Our Ref: SZC NMC
Date: 24 June 2026
Enquiries to: [REDACTED]
Email: [REDACTED]@suffolk.gov.uk

Suffolk County Council response to Sizewell C Non-Material Change Application Reference EN010012

Appendix A Detailed comments on the 8 Changes of the NMC application

DRAWING TITLE:
 SIZEWELL LINK ROAD
 RIGHTS OF WAY PLANS - SHEET 19 OF 28

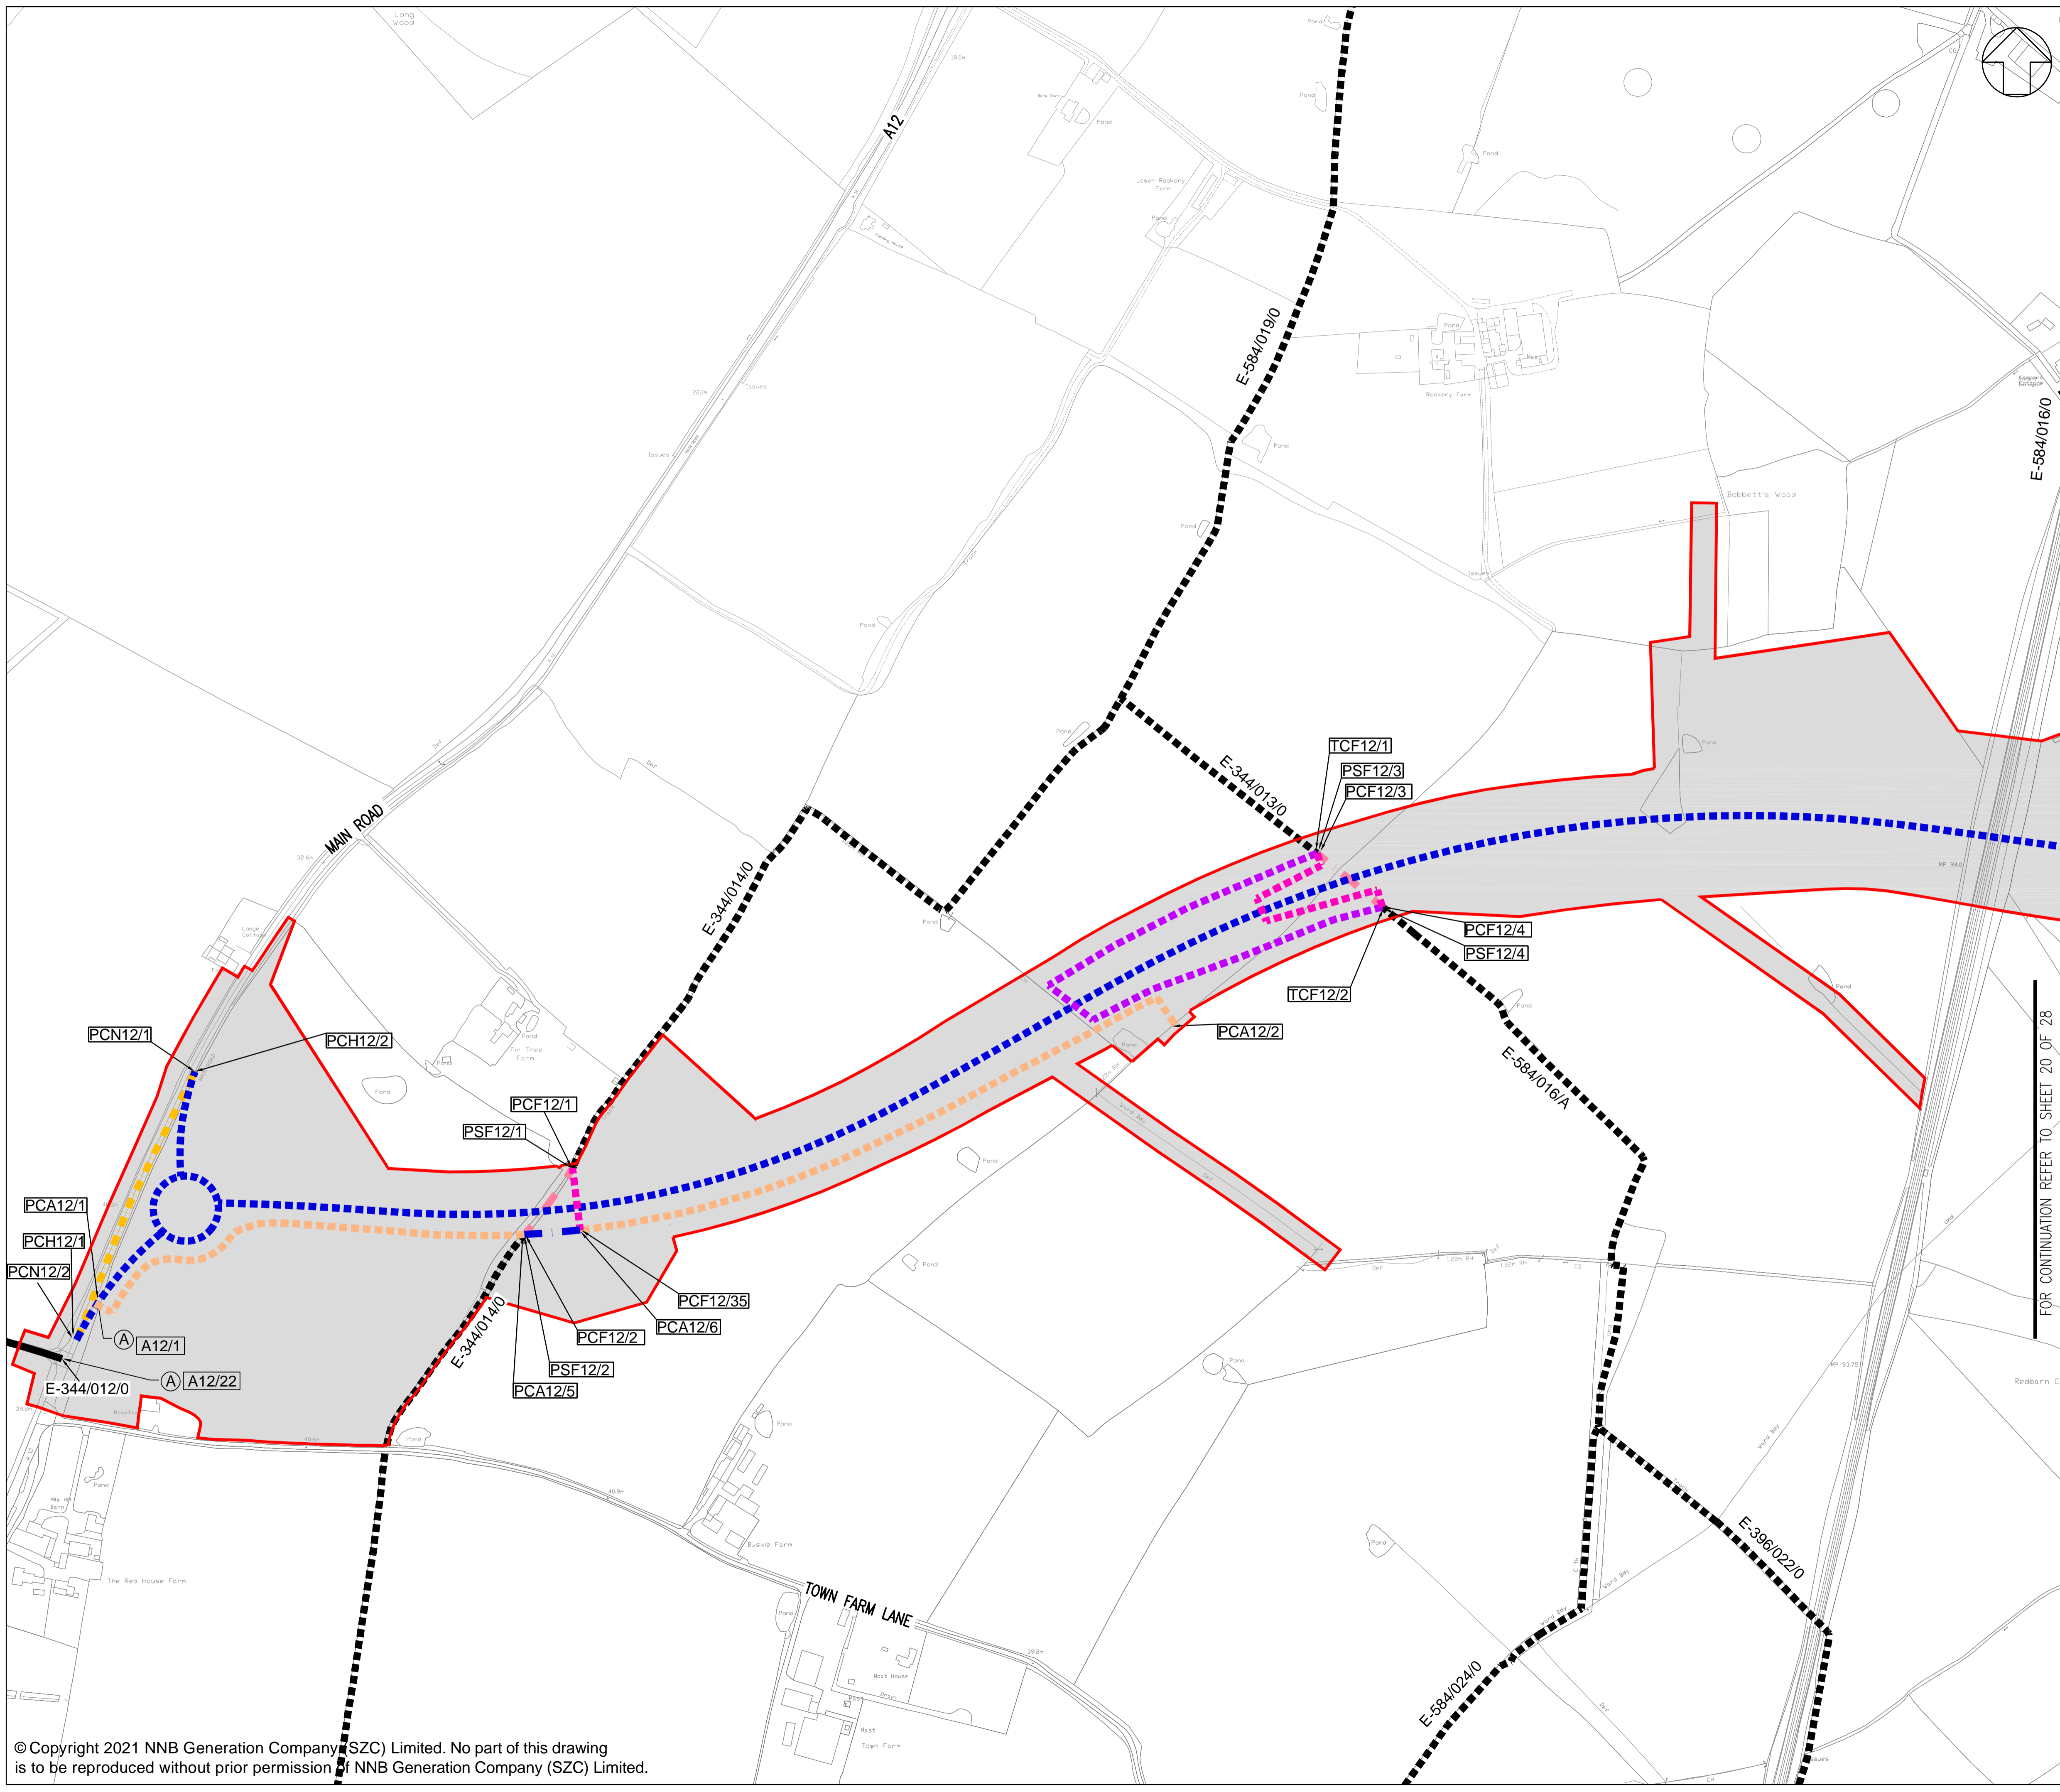
ROW Plan Sheet 19 - omission from plan and schedule

To be consistent with other ROW Plans, the access track between PCF12/35 towards PCA12/2 should be shown on the plan as a joint new permanent highway (footpath) and private means of access with the same line style as is shown between PCF12/35 and PCF12/2. East of PCA12/2, this should be depicted as new permanent highway (footpath) and be included in Schedule 11 Column (3) as footpath. The extent is indicated by the green line on Figure 6.
